From: Simon Davis
Sent: 07 January 2020 17:39
To: Planning Scanning
Subject: FW: Inglenook P/58/19/PL

From: Richard Dollamore [REDACTED]
Sent: 07 January 2020 14:36
To: Simon Davis [REDACTED]
Cc: 'Gareth Giles | Whaleback' [REDACTED]
[REDACTED]
Subject: RE: Inglenook P/58/19/PL

Refuse Vehicle
Swept Path Analysis

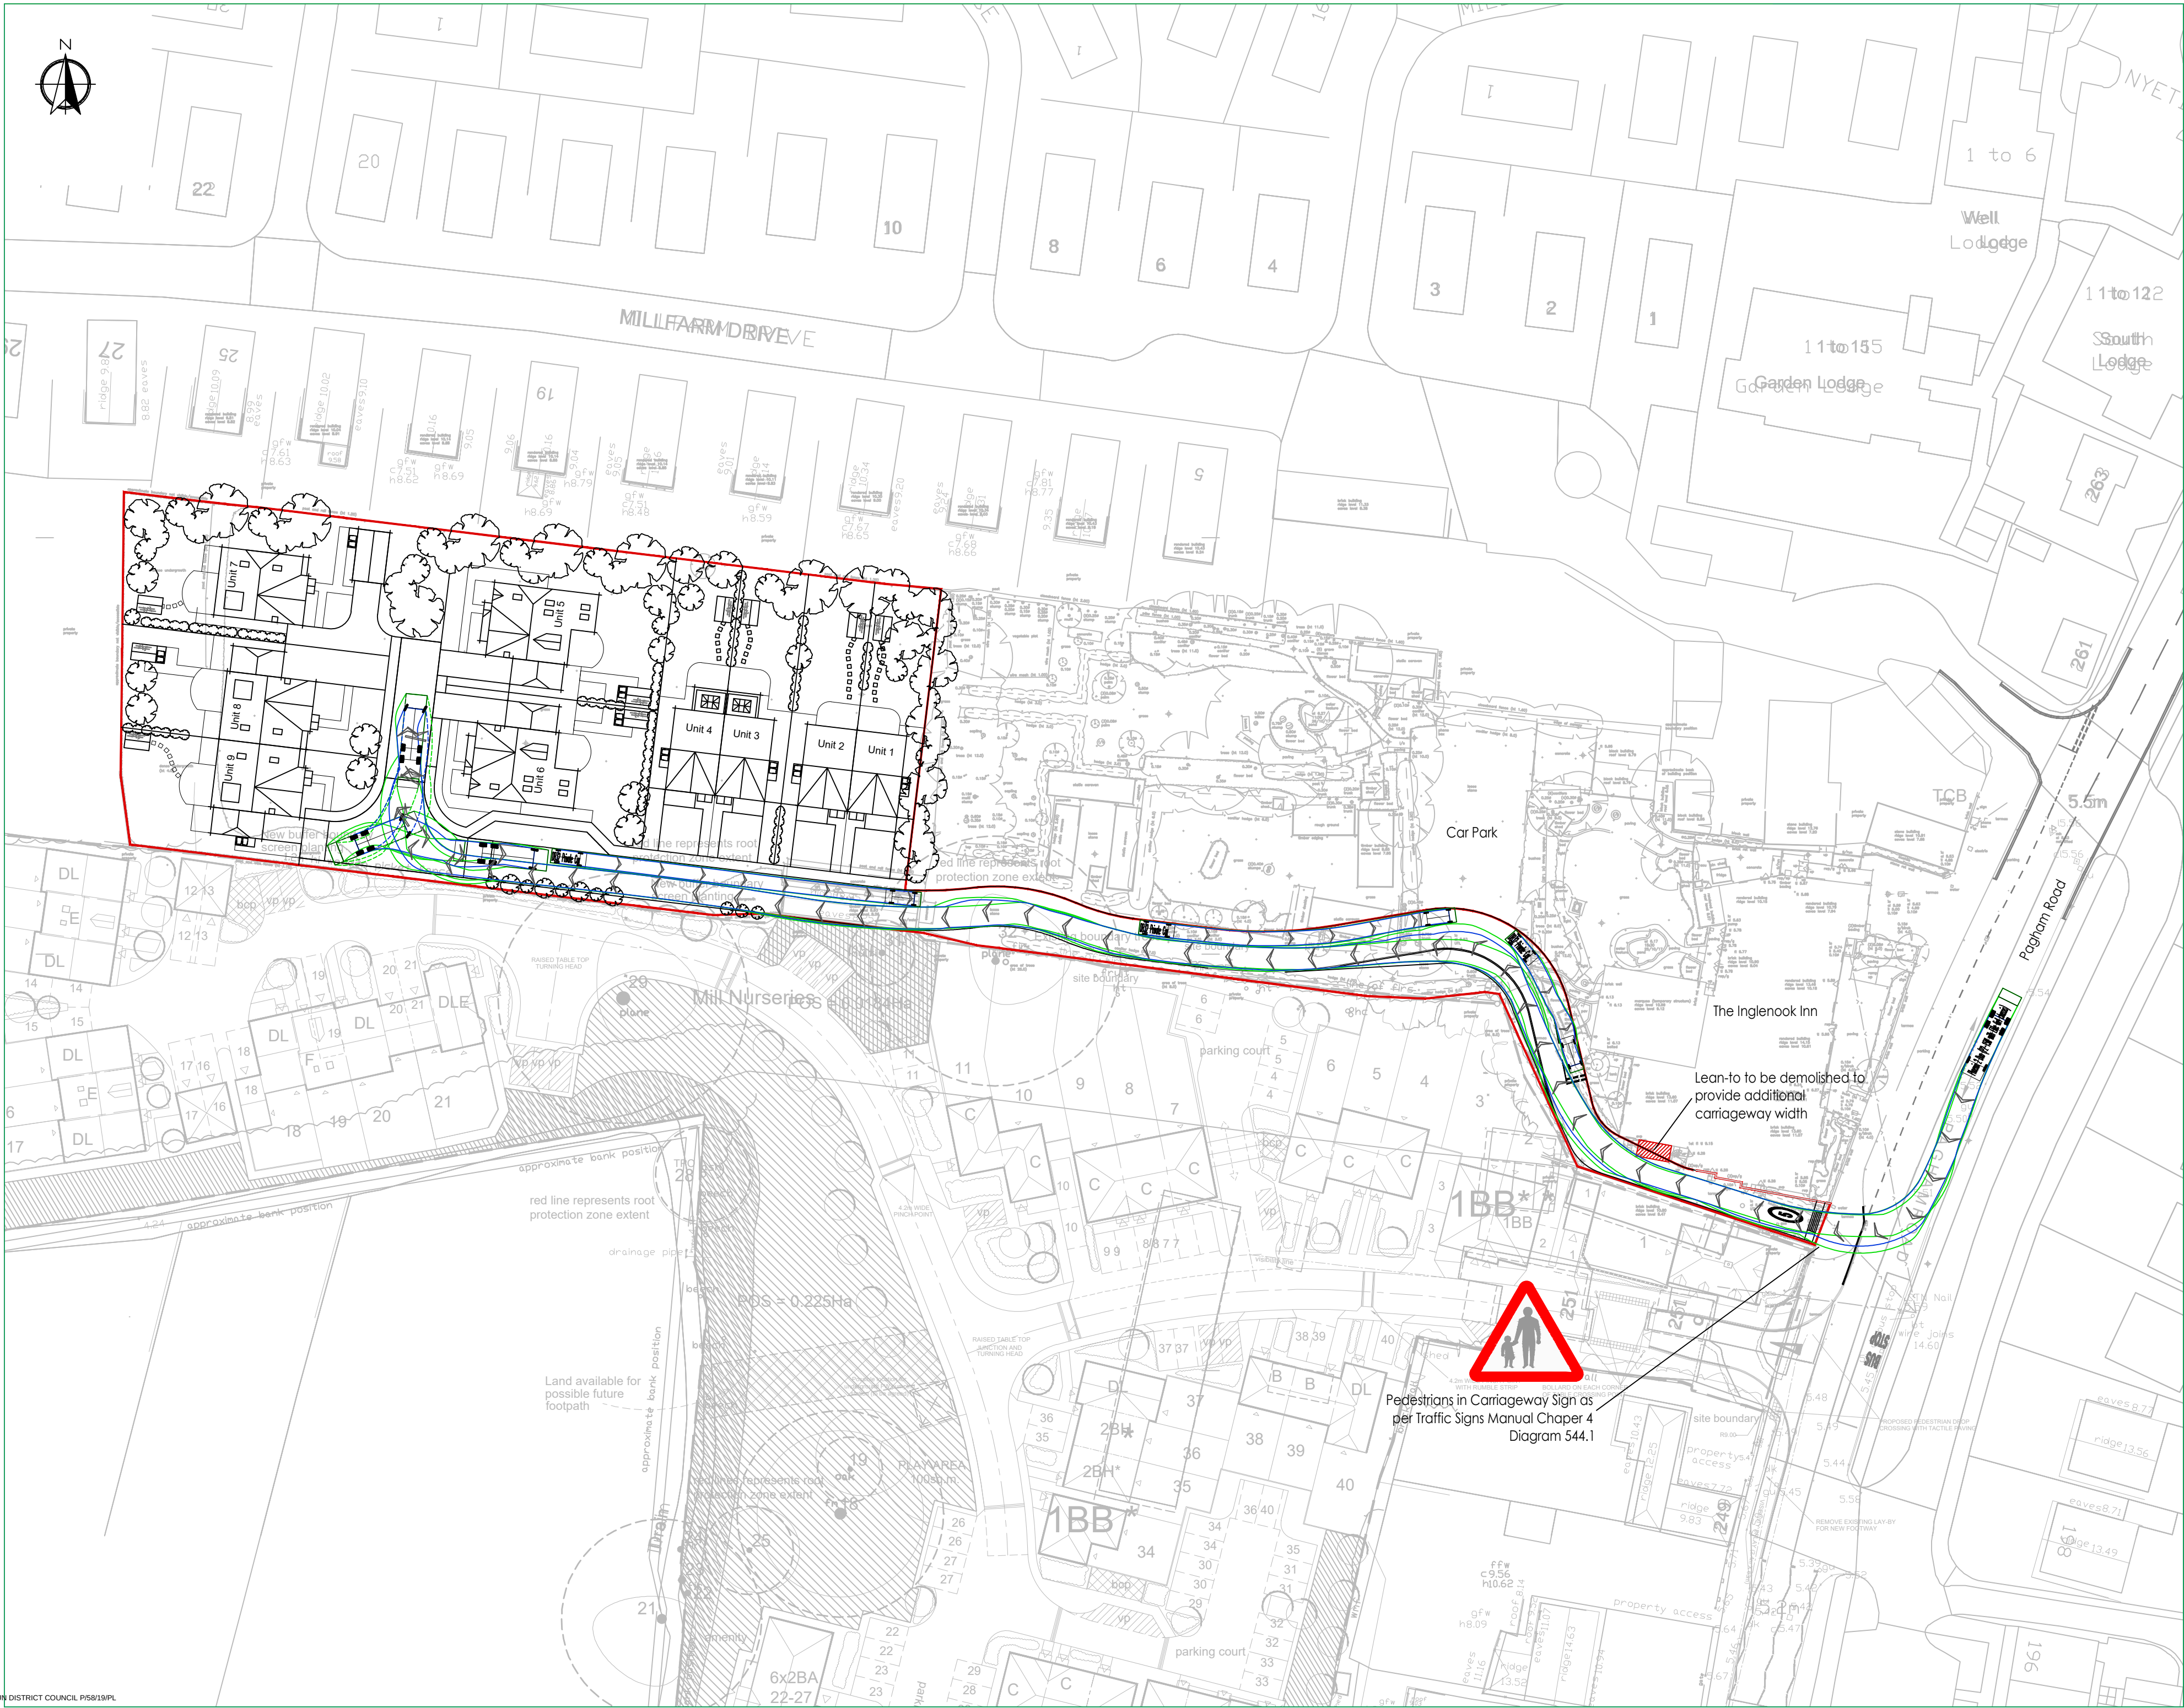
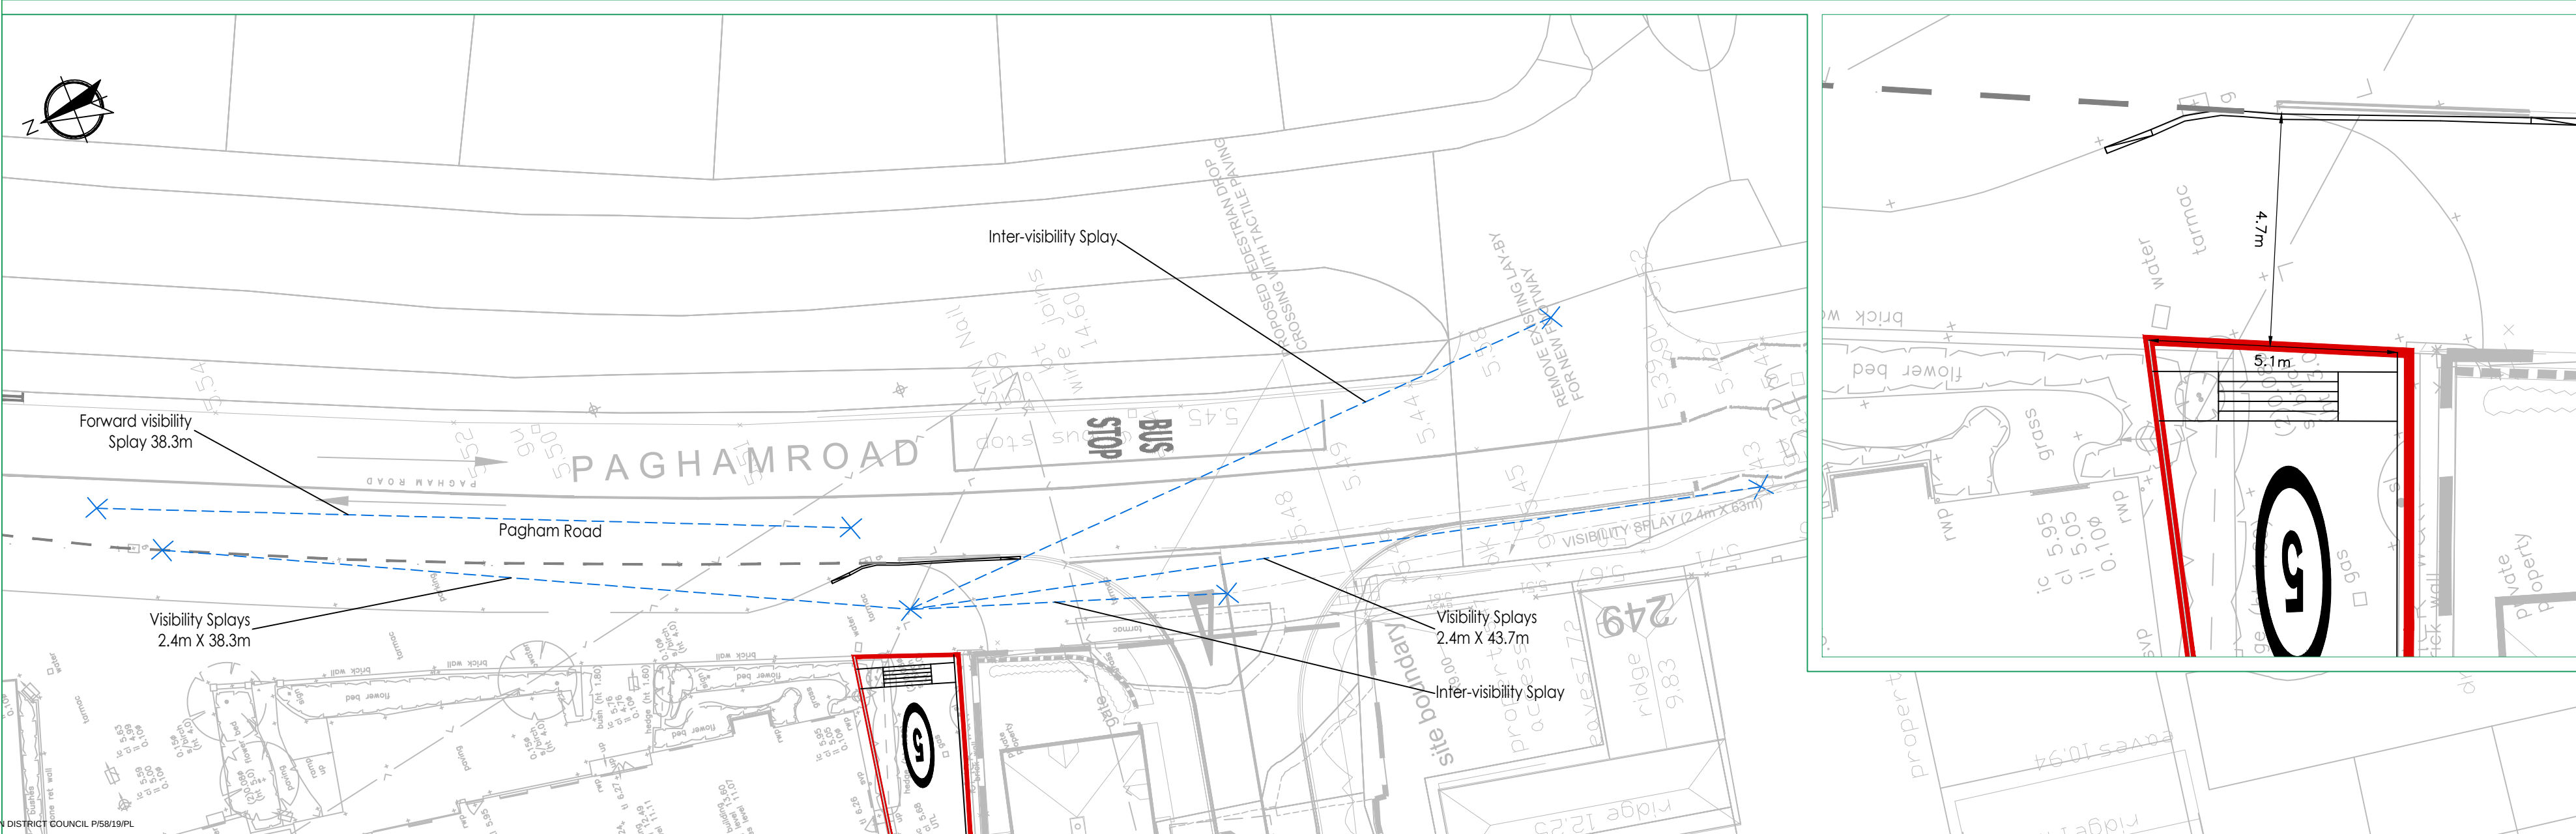
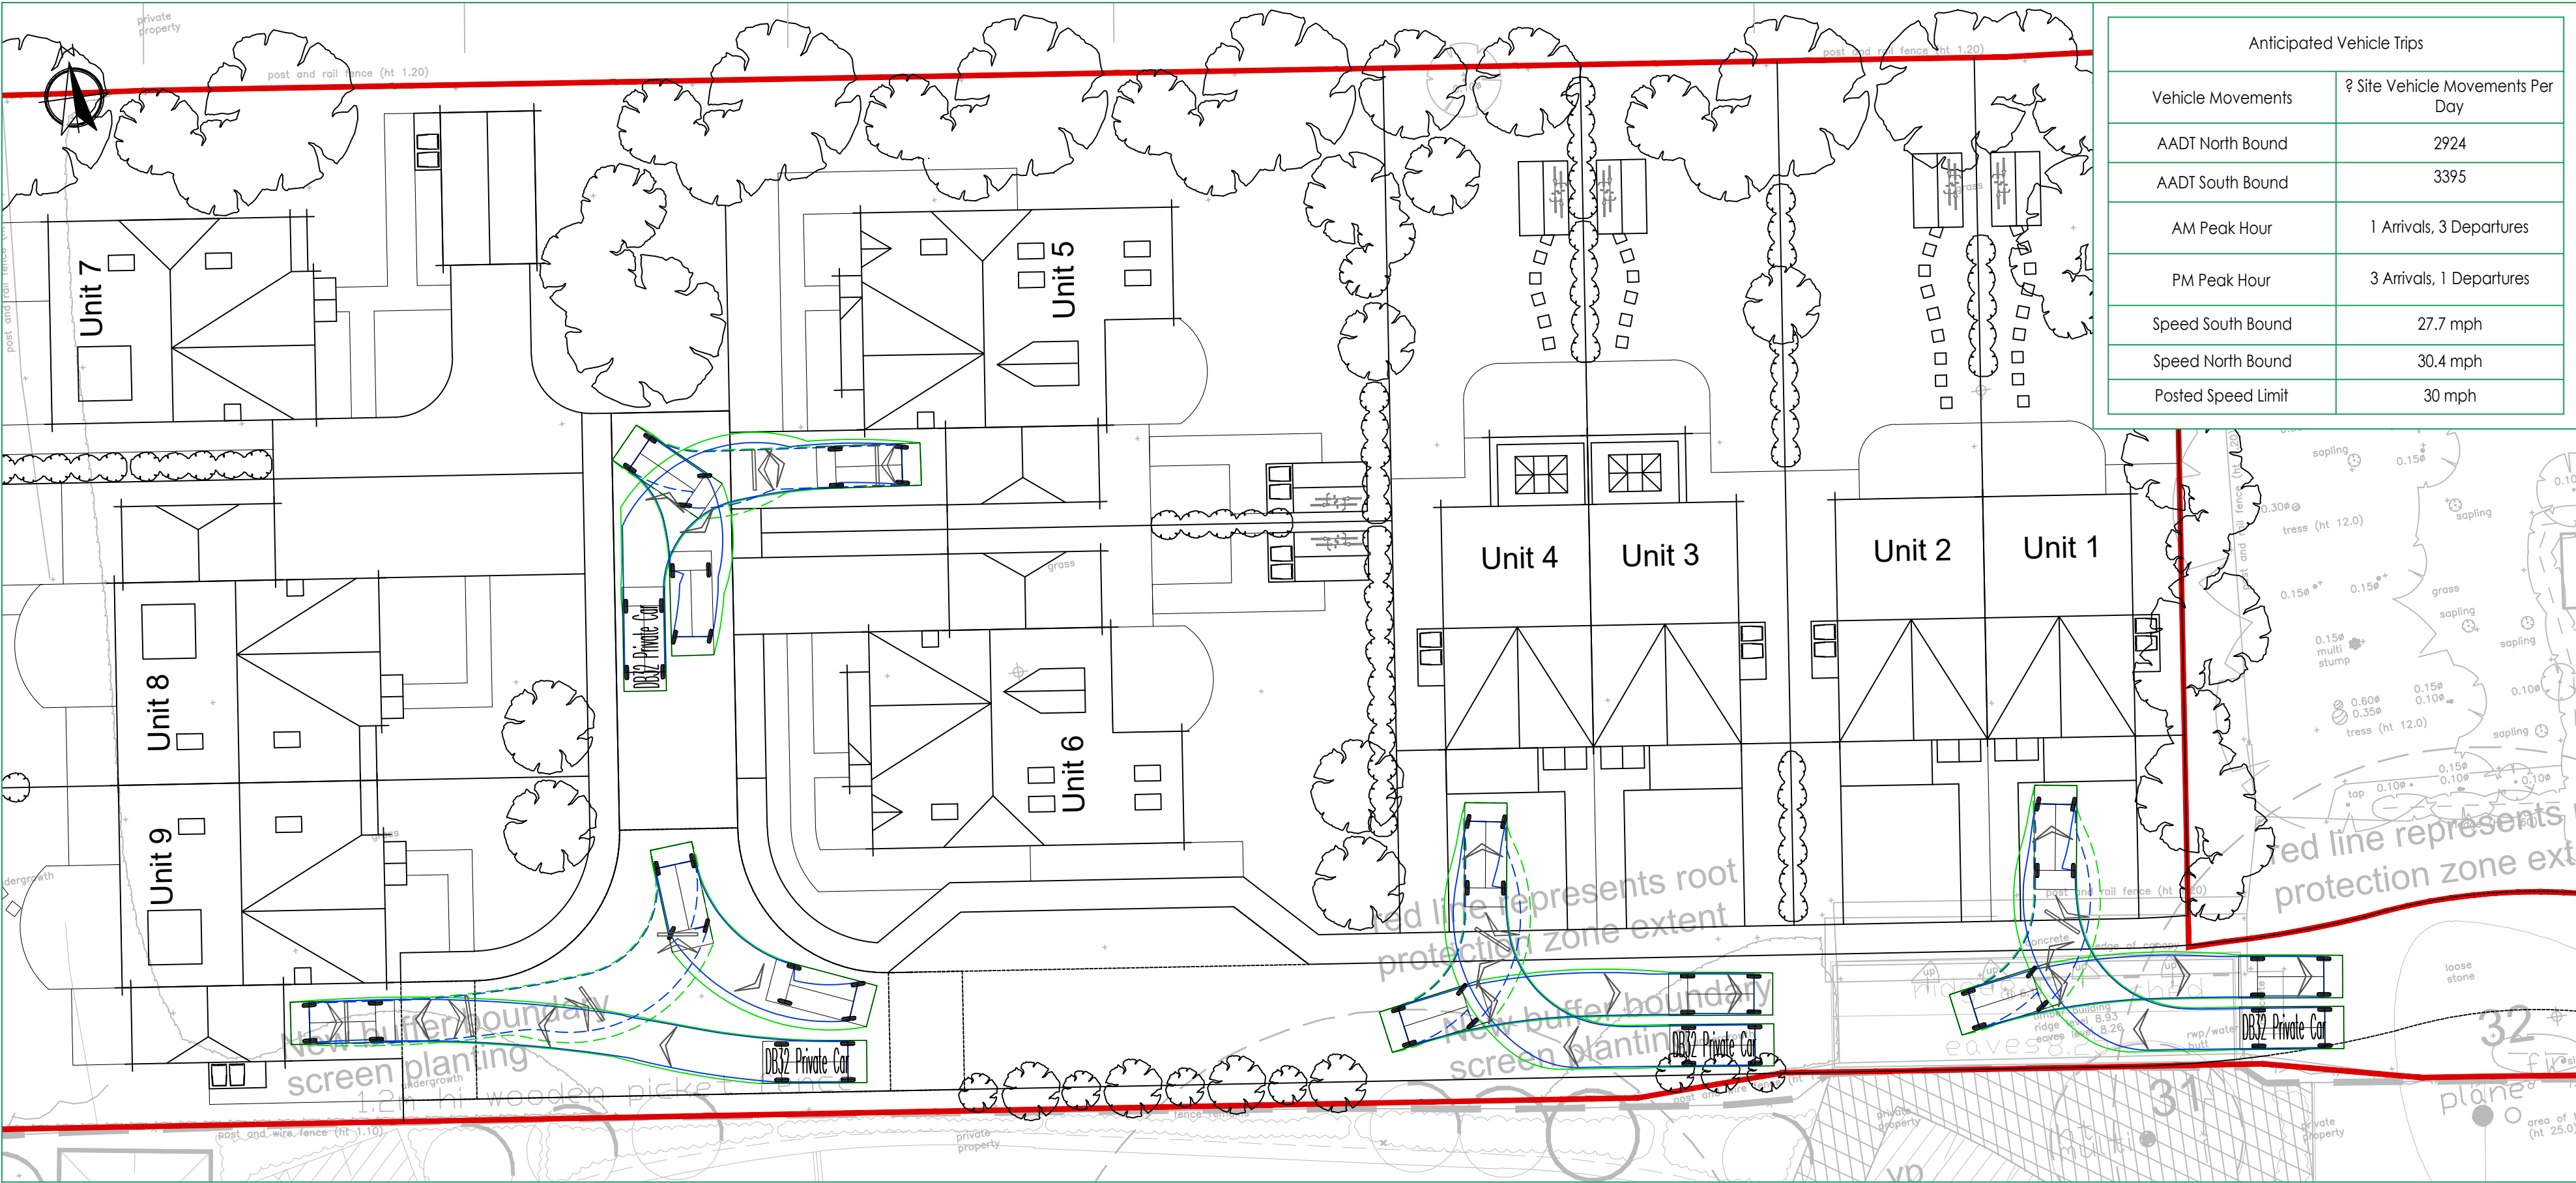
1. The report states that 'a refuse vehicle would not be able to make a turn with the present arrangements without parking restrictions.' However, this does not appear to be correct. The turn would not be possible if it was made on the same radius but it is clear that a tighter turning circle can be achieved. i.e. if a vehicle can turn left out of the site onto the north-bound carriageway then it can also turn right (from a position in the middle of the road, to the right of any parked vehicles) into the site.

6. The report refers to the swept path being 'very close to lamp columns and steps with no margin of error.' However, the columns are proposed to be removed.
